PROJECT NO. 1001891	APPLICATION NO. 02DRB-01791
PROJECT NAME SEVILLE #3	
EPC APPLICATION NO. S-T	Margo
APPLICANT / AGENT	PHONE NO. 897-3366
ZONE ATLAS PAGE A-10

### 6. Project # 1001891

**Project #1001891**  
**Application # 02DRB-00597, 02DRB-00598**  
**Seville Subdivision, Unit 3**

CITY OF ALBUQUERQUE PUBLIC WORKS DEPARTMENT ENGINEERING GROUP	
SEVILLE SUBDIVISION – UNIT 3 GRADING & DRAINAGE PLAN – PLATE 3	
Design Review Committee	City Engineer Approval
Mo./Day/Yr.	Mo./Day/Yr.
City Project No. XXXX.XX	Zone Map No. A-10-Z
Sheet 2	Of 3

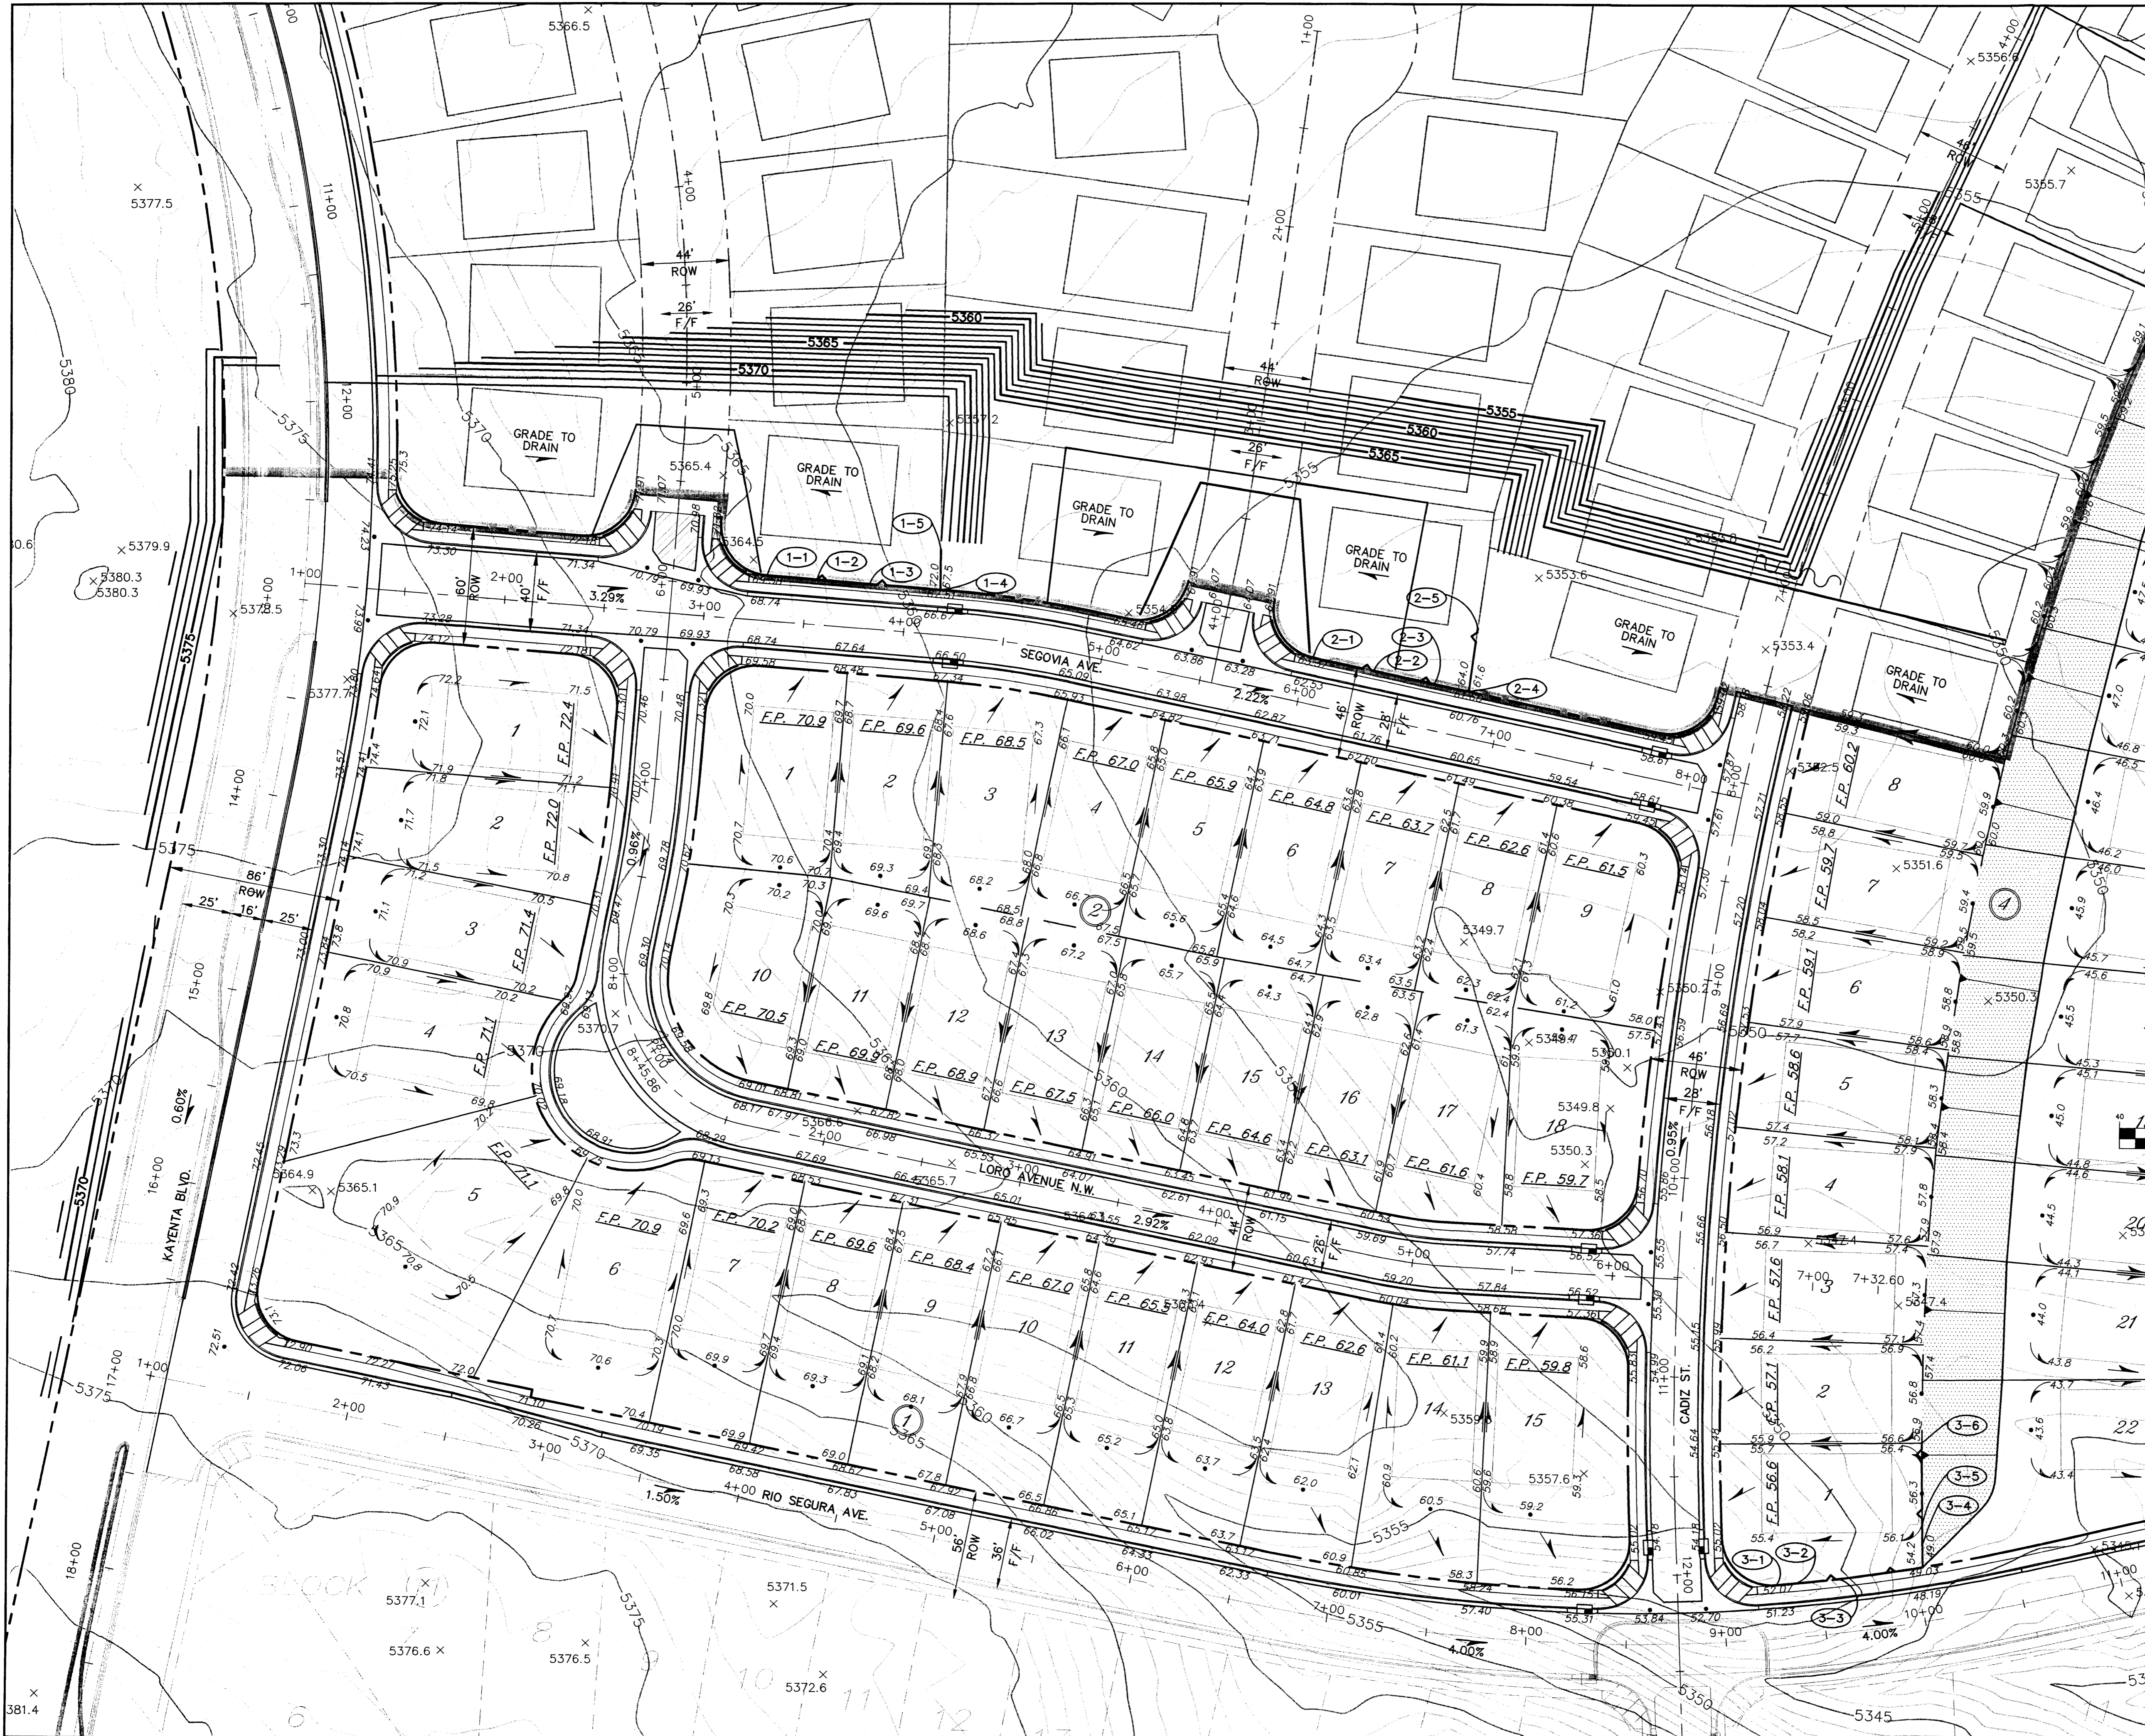
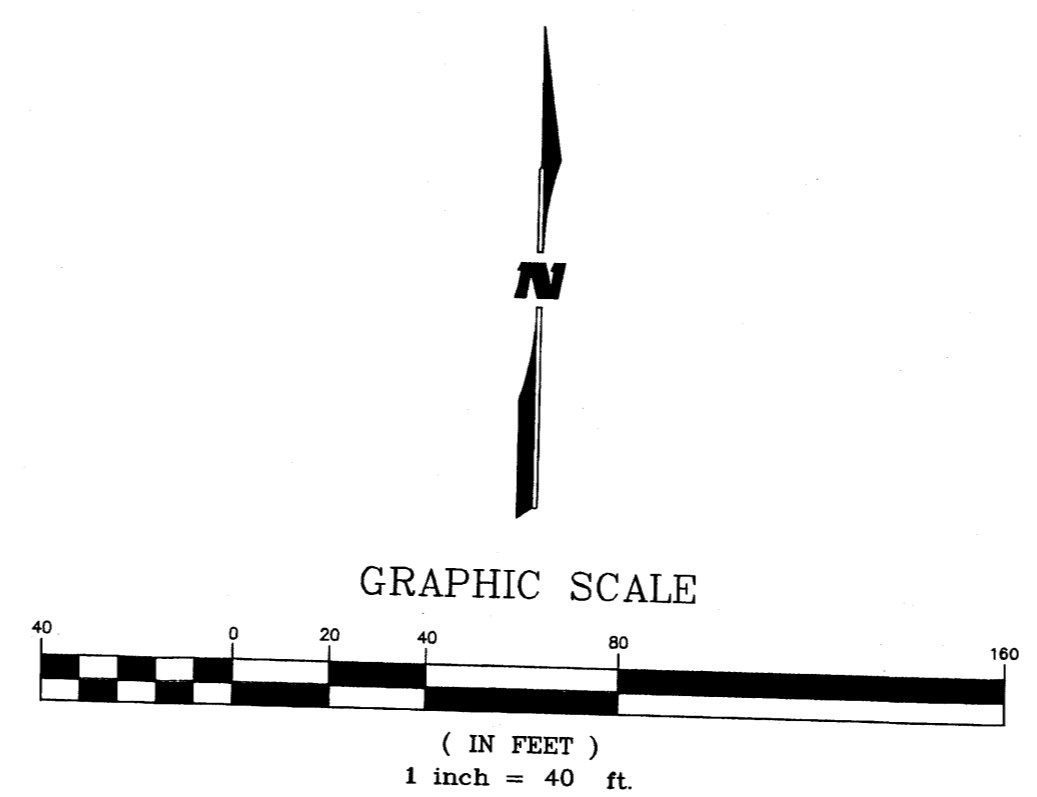
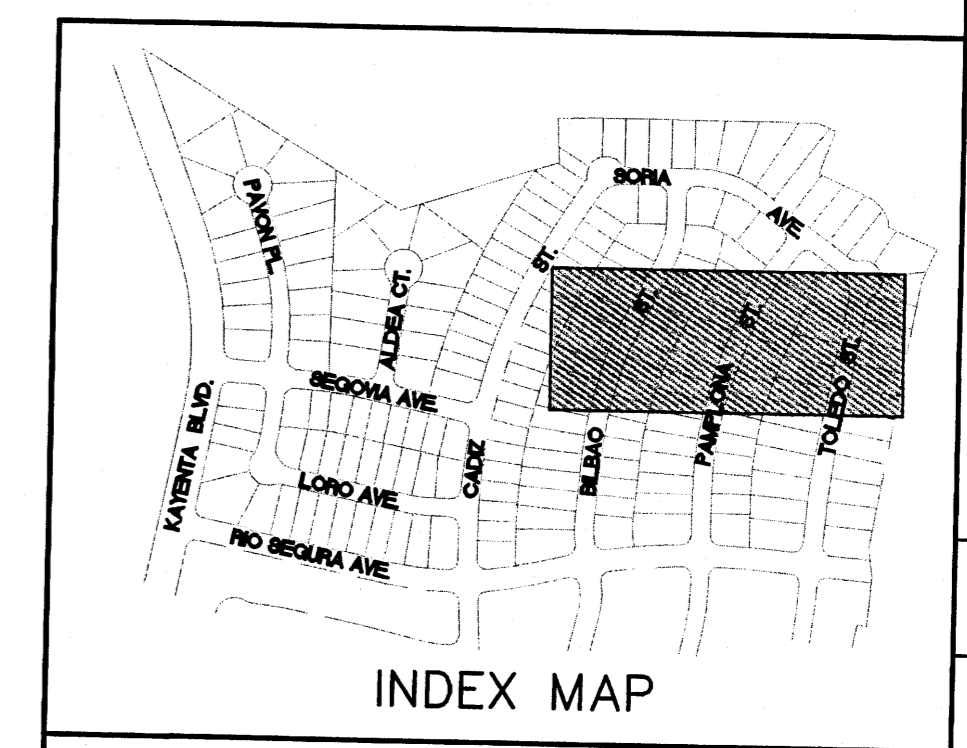
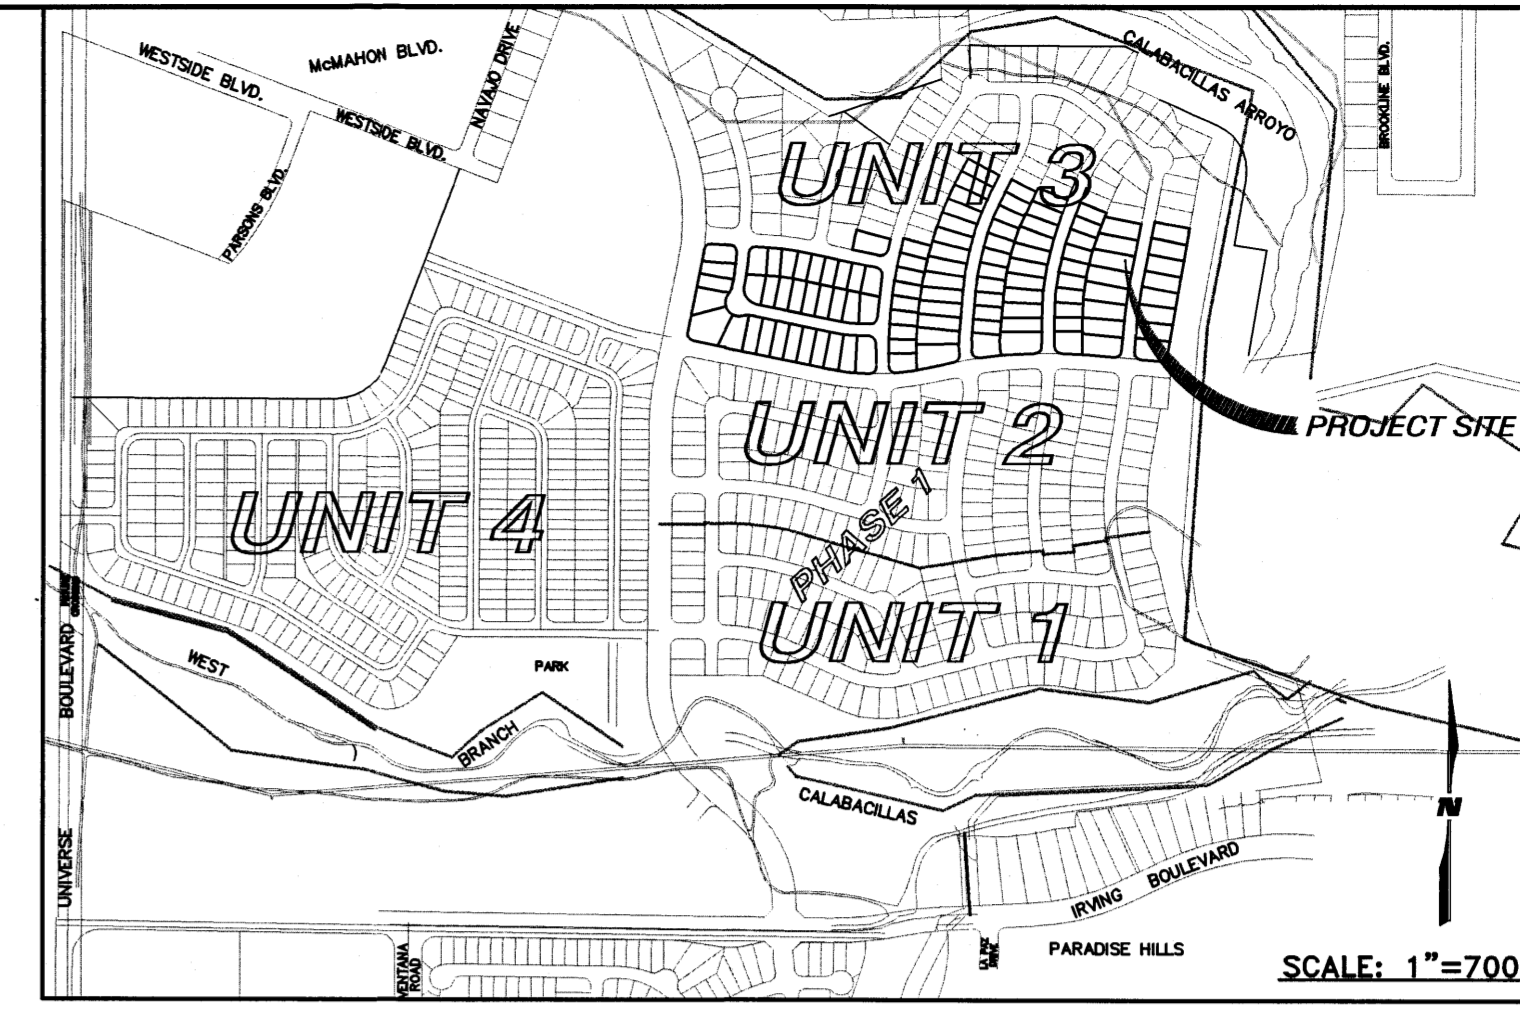
1. According to the Subdivision Regulations, grades are to be blended to the extent practicable. Please provide a letter of explanation/justification for the use of retaining walls.
2. What are the proposed lot sizes? Please provide a table showing this information.
3. Add the zoning classification to the final plat.
4. No objection to the temporary deferral of sidewalk construction. Defer to Transportation Development.

VICINITY MAP
EXHIBIT C
 DATE 5/15/02

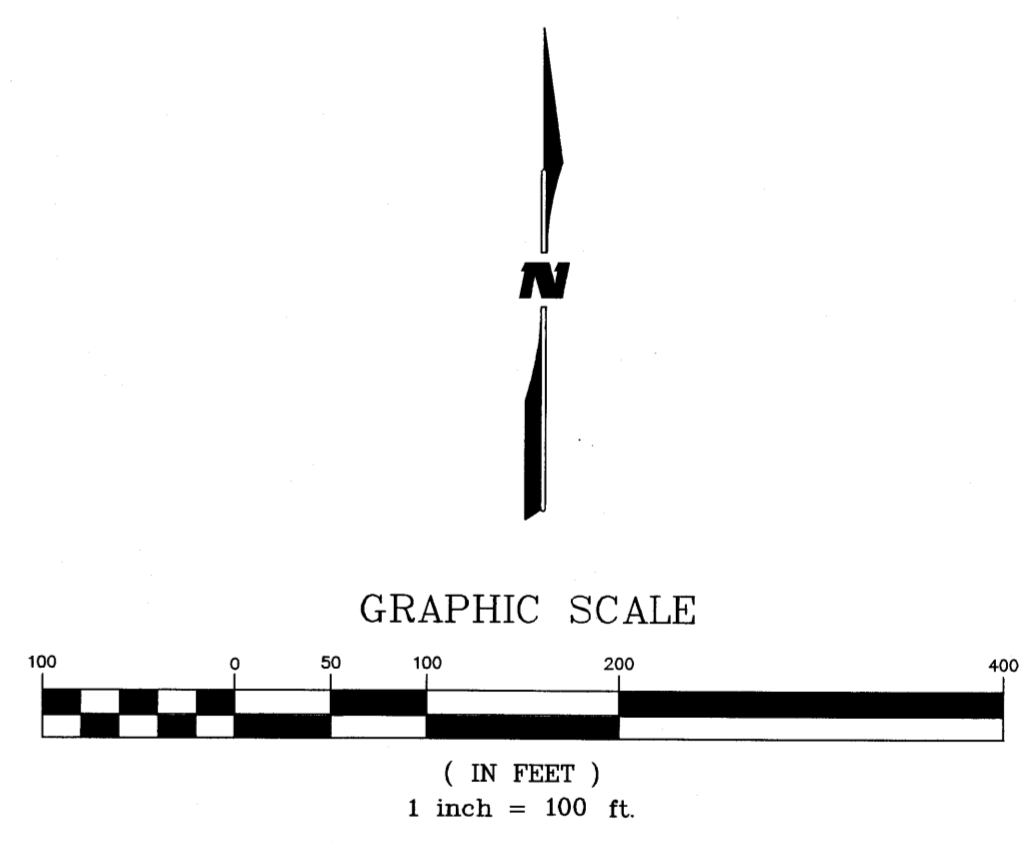
The missing street names and right-of-way widths need to be included. Comments on the infrastructure list. The sidewalk deferral exhibit should have the street names indicated on it.
